## KITTITAS COUNTY COMMUNITY DEVELOPMENT SERVICES

Subject: PD-16-00001 & LP-17-00004 The Commons at Dry Creek PUD & Preliminary Plat  
Additional Information Required

RE: Ecology SEPA 6503 Comments for The Commons at Dry Creek preliminary plat

DATA FORM 1 (Revised)

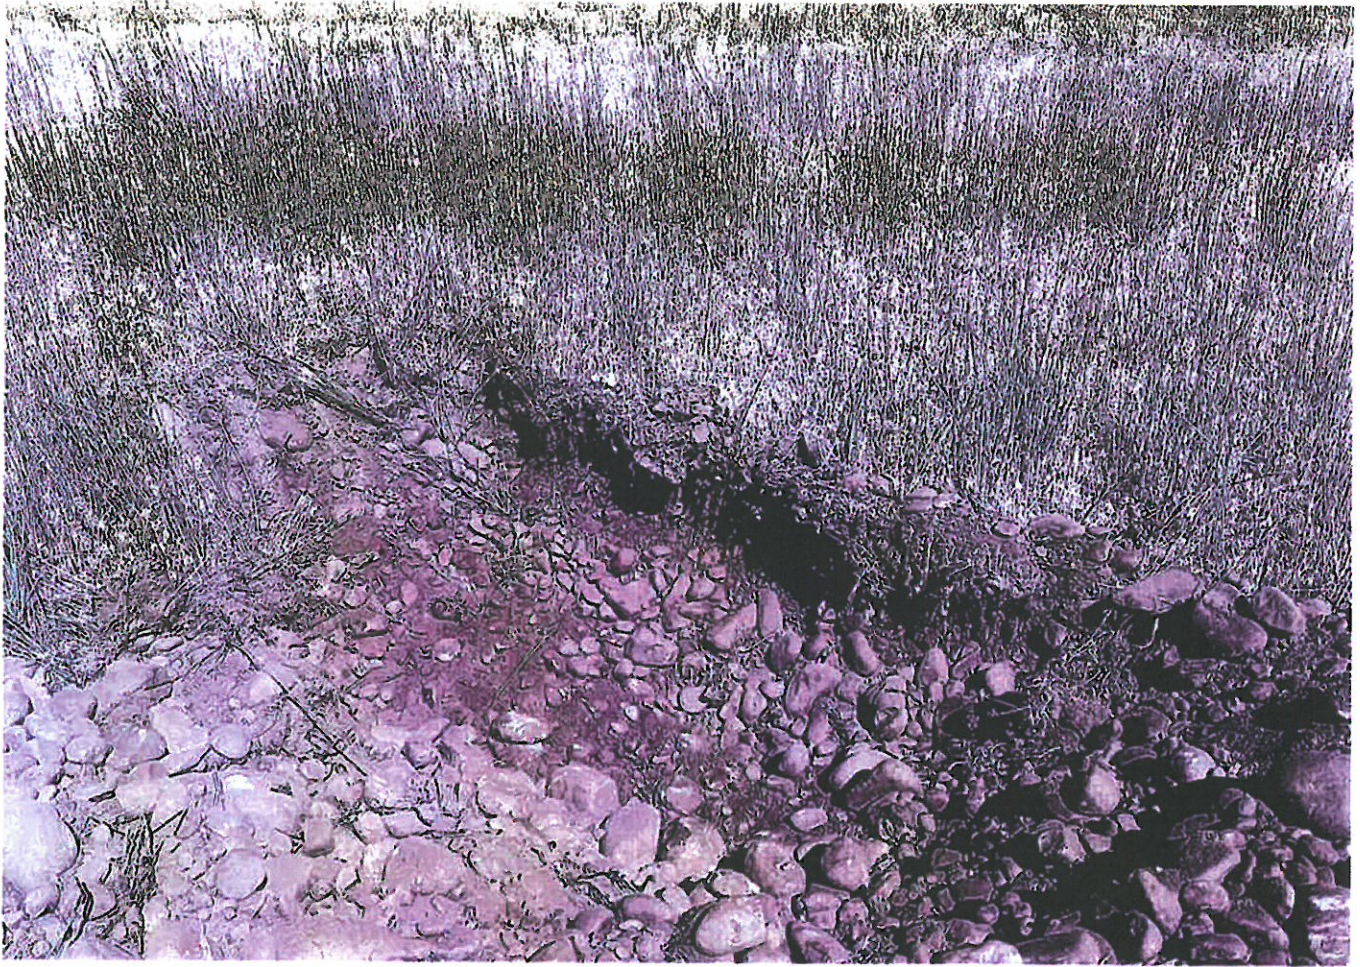
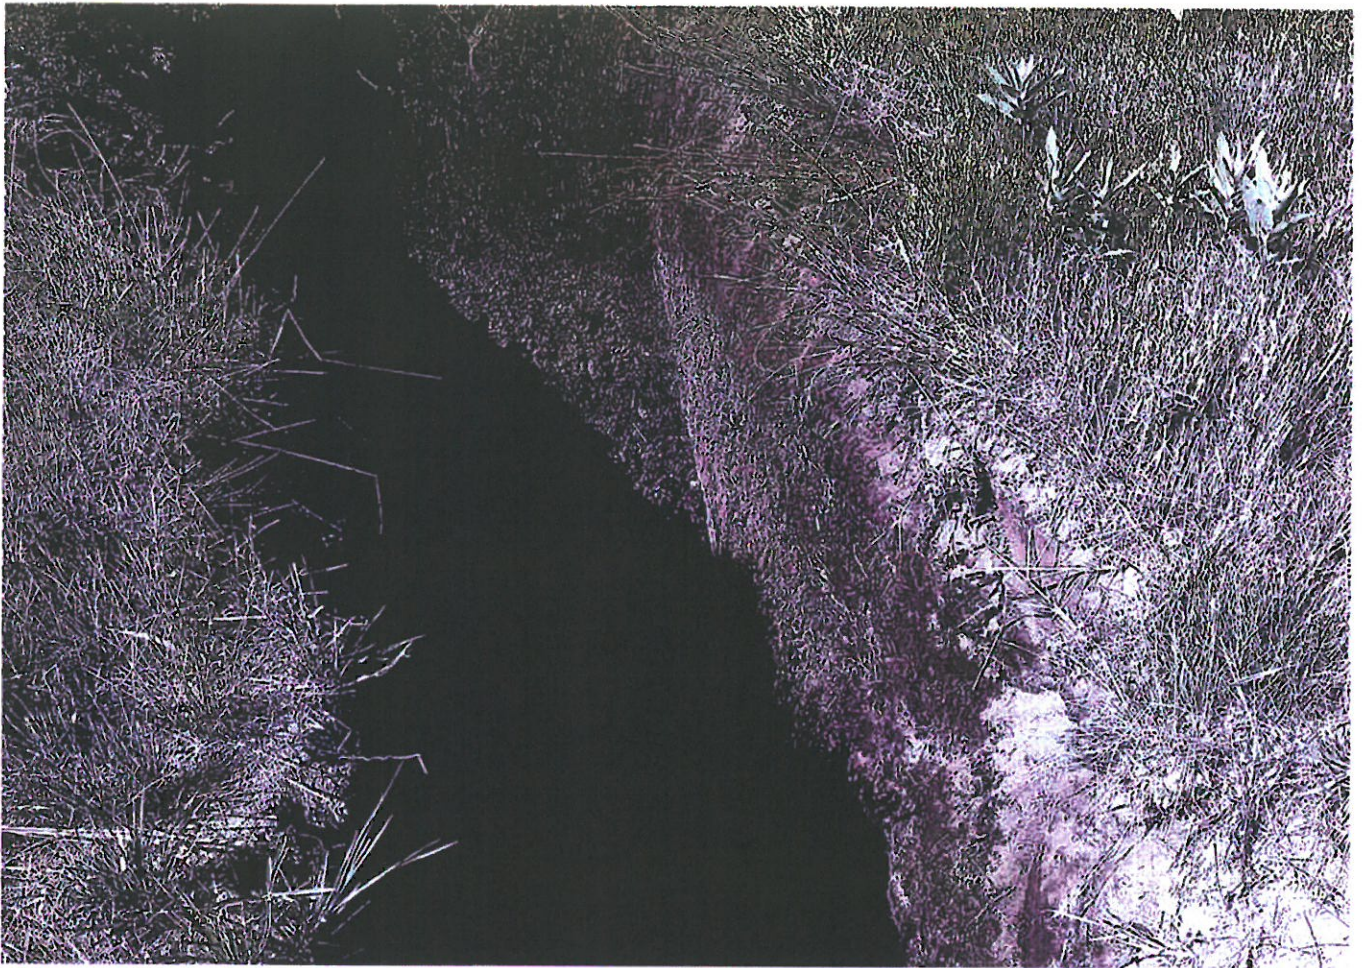
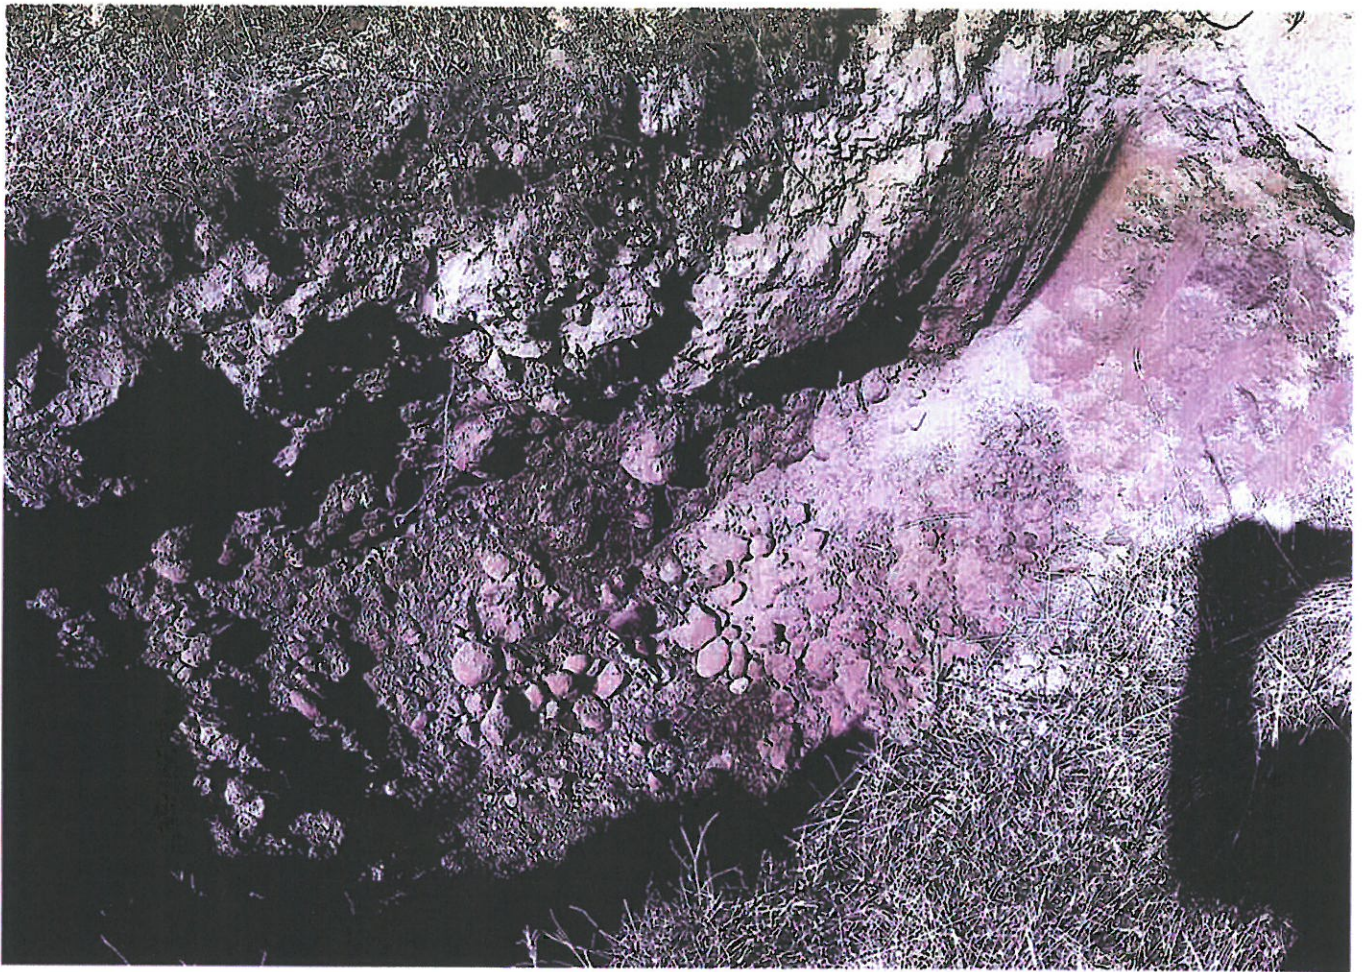
2. A single datasheet was prepared for all four plots investigated. Each plot must have a separate data sheet to show the characteristics found at each location investigated on the property. Combining test plots on a data sheet is not standard practice and does not follow agency guidance or methodology for collecting data.

3. Test holes were dug using an excavator. This method reduces many details of the soil profile that are necessary to correctly identify soil characteristics.

4. The Arid West Data sheet was not utilized for collecting data, resulting in incomplete collection of necessary data to make a wetland determination. The most current National Wetland Plant List for Washington, at the time of data collection, was not applied. Within the Arid West Region Supplement, five types of wetland status indicators are used. The plus (+) and minus (-) modifiers are no longer applicable. The horsetail (*Equisetum*) species should be identified to species in order to apply the proper indicator status.

MDJ CONTRACTORS
CURRIER HEIGHTS PUD
PRELIMINARY SITE PLAN

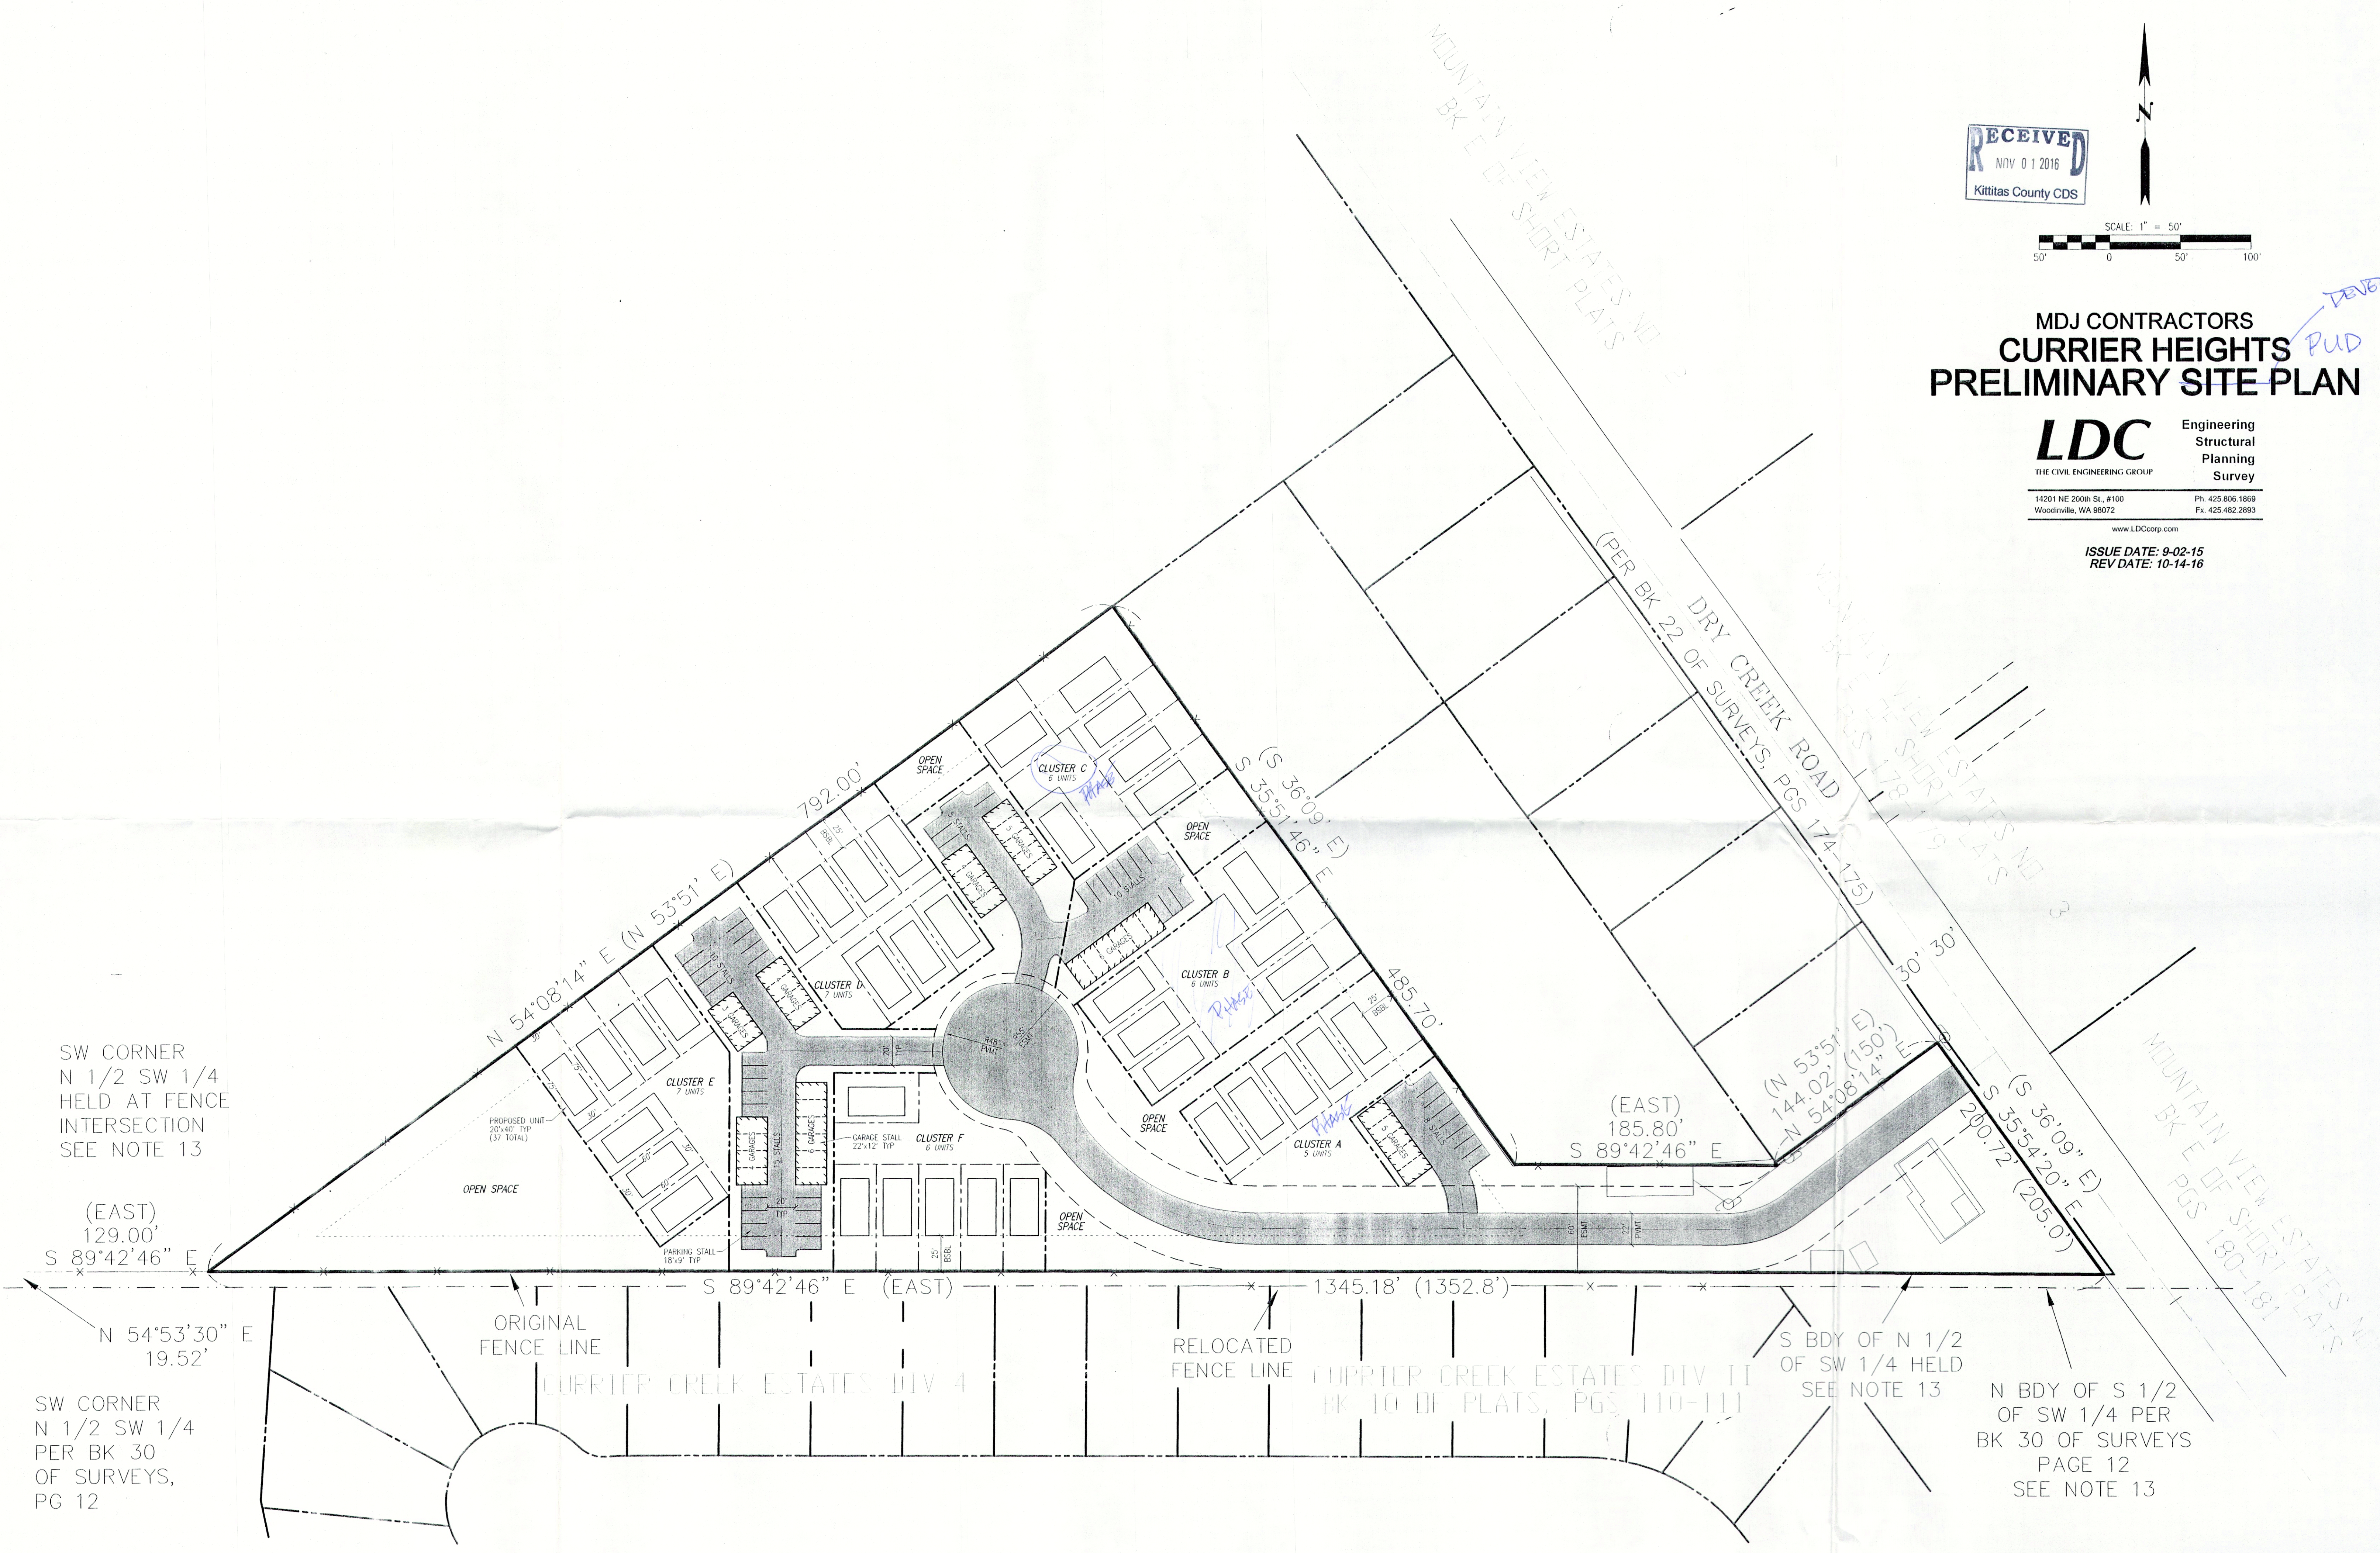
5. An existing swale is mentioned within the Wetland Inventory, however it is not identified on the maps provided, nor is it clear if a data point was taken within the existing feature. The topographic feature should be evaluated further for wetland conditions.

Dry Creek is in close proximity to the Jackson property; therefore, the ordinary high water mark, stream classification and regulated buffer setback need to be identified. Any regulated buffer overlap on The Commons at Dry Creek should be identified and shown on plan sheets.

1. The Department of Ecology letter stated that the wetland inventory used for the property utilized incorrect methodology for determining whether or not wetlands are present on or adjacent to the area proposed for development. The letter included resource documents for appropriate preparation of a wetland determination. Therefore, please submit a new wetland determination meeting the requirements of the Department of Ecology.
